Application ref: A/26/21/RES

Description: Approval of reserved matters following outline consent A/44/17/OUT for appearance, landscaping, layout & scale for the demolition of existing buildings on site & erection of a mixed use development comprising of 90 No. residential dwellings & a care home & ancillary facilities including railway crossing together with associated access, car parking & landscaping. This application also lies within the parishes of Rustington & Littlehampton.

Location: Land west of Brook Lane and South of A259 Angmering BN16 3JL

Summary recommendation: Recommend **objection in general to the hard and soft landscape details** contained in this application A/26/21/RES. The detail is not sufficient enough in detail to be able to recommend support of the proposal.

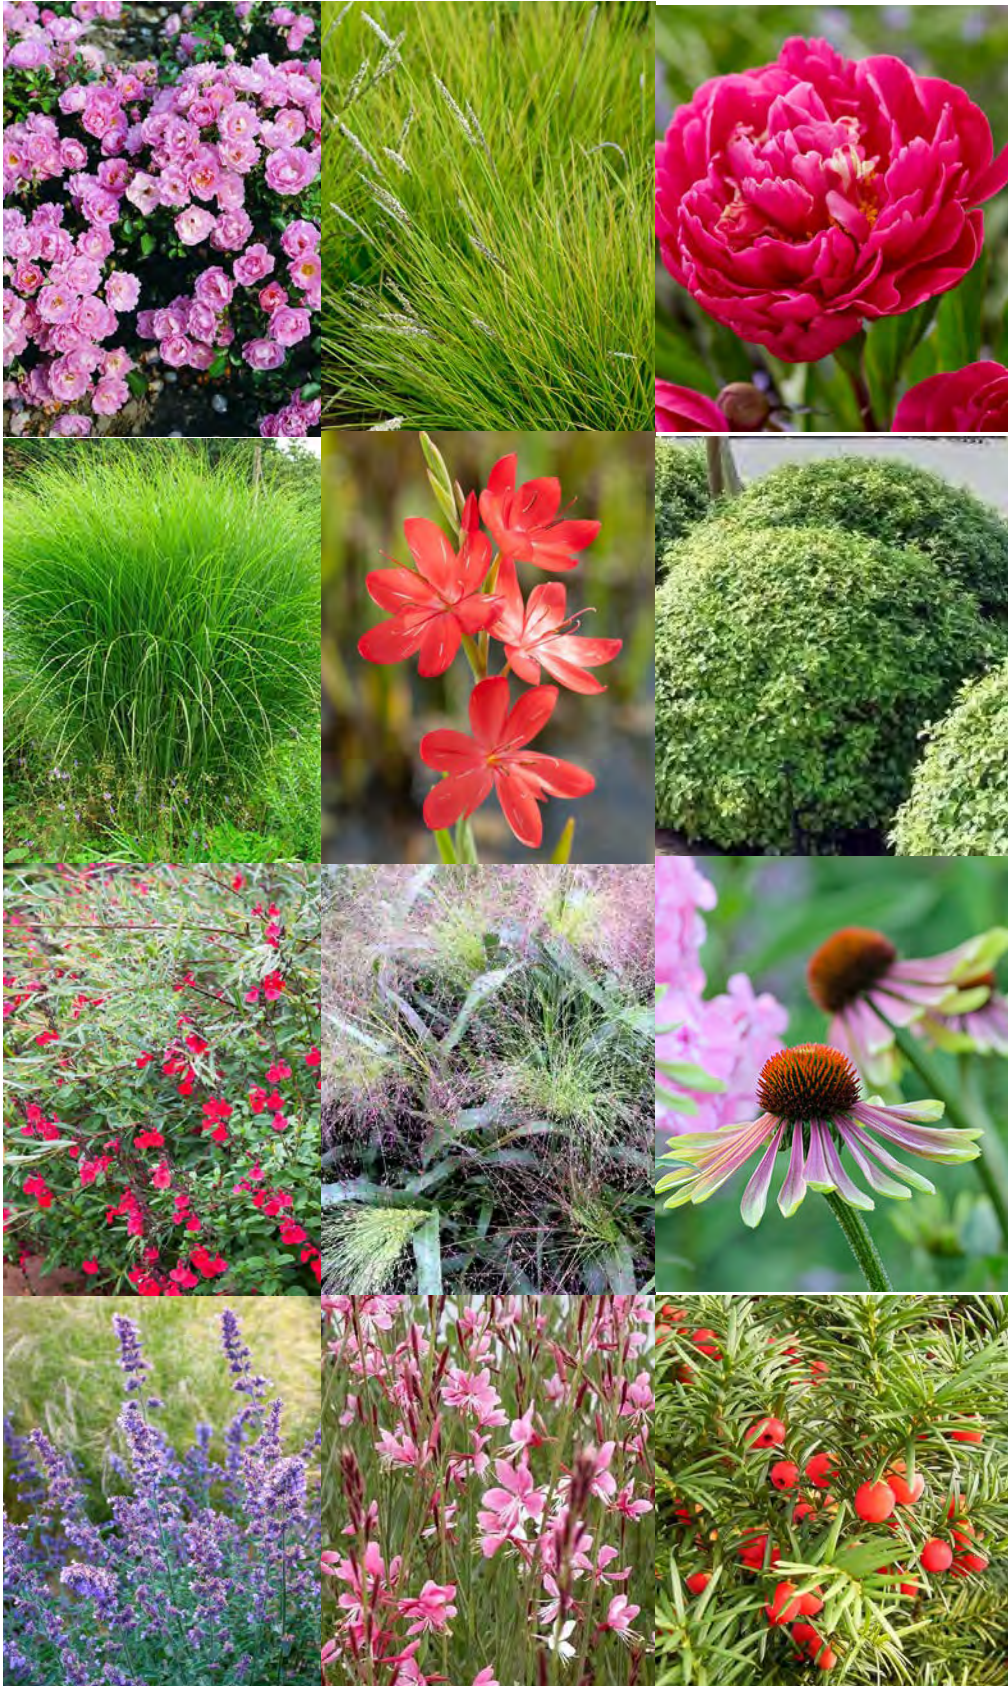
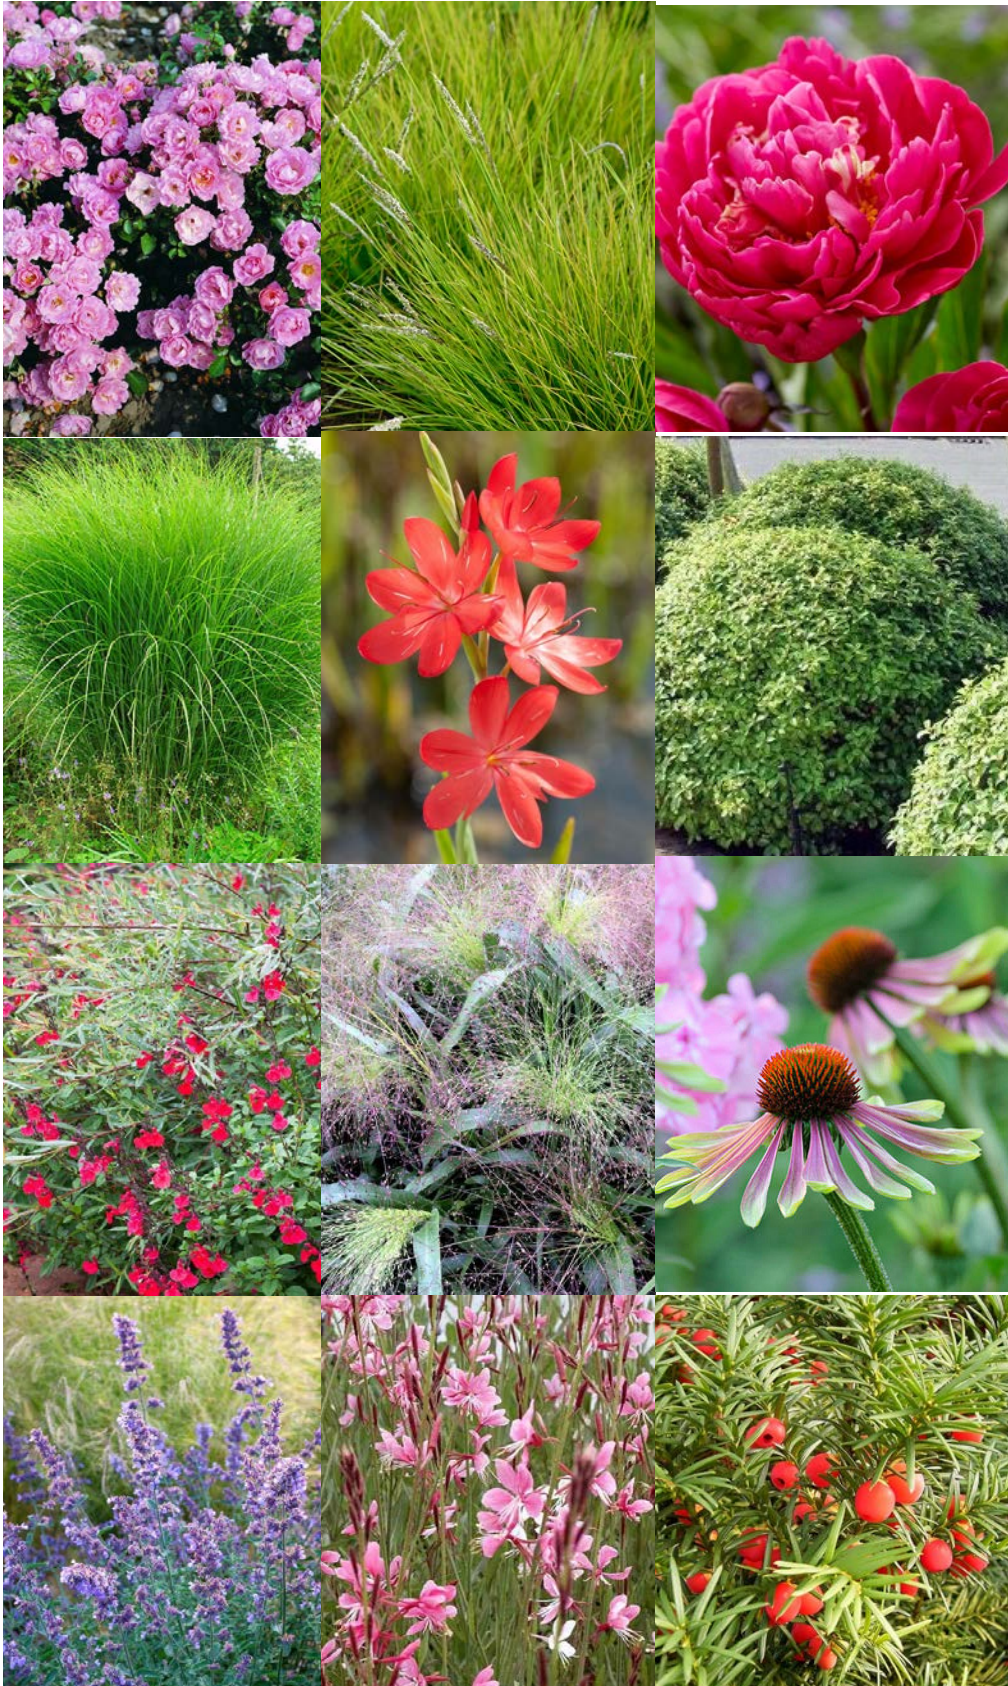
- The soft landscape detail in general is detailed with species choice appearing suitable for location, however the information has not been submitted in enough detail ie Plant Schedule 122-SCH-001-Rev P1 refers to shrub % mixes and not actual plant quantities and associated drawings detail Planting mix's ie CH3, CH2, infrastructure planting Mix A-D but needs to list **actual quantities** in these locations. **This information needs to be clearly shown in plan form for each location.**

- **Care Home Planting** Plan 176-205-Rev P1 shows the layout of the care home garden areas. These do not appear suitable for use, **contain no enclosed garden areas and generally appear as broad generic landscape areas.** The care home setting needs to cater for its residents, visitors and care home staff with well-formed landscaped areas which provide safe and stimulating areas that are fit for purpose. The open area to the immediate east of the care home building would appear to be a pond area with steeply sloping sides and no reference to fencing or protection of residents in close proximity to this feature and potential water body. **This drainage feature would appear inappropriate and pose a danger in this location and within the care home setting.**

- DAS Design and Access statement Pages 42-48 Show indicative planting only, Pages 35-41 shows indicative play features which are largely blanked out and therefore providing no useful information.
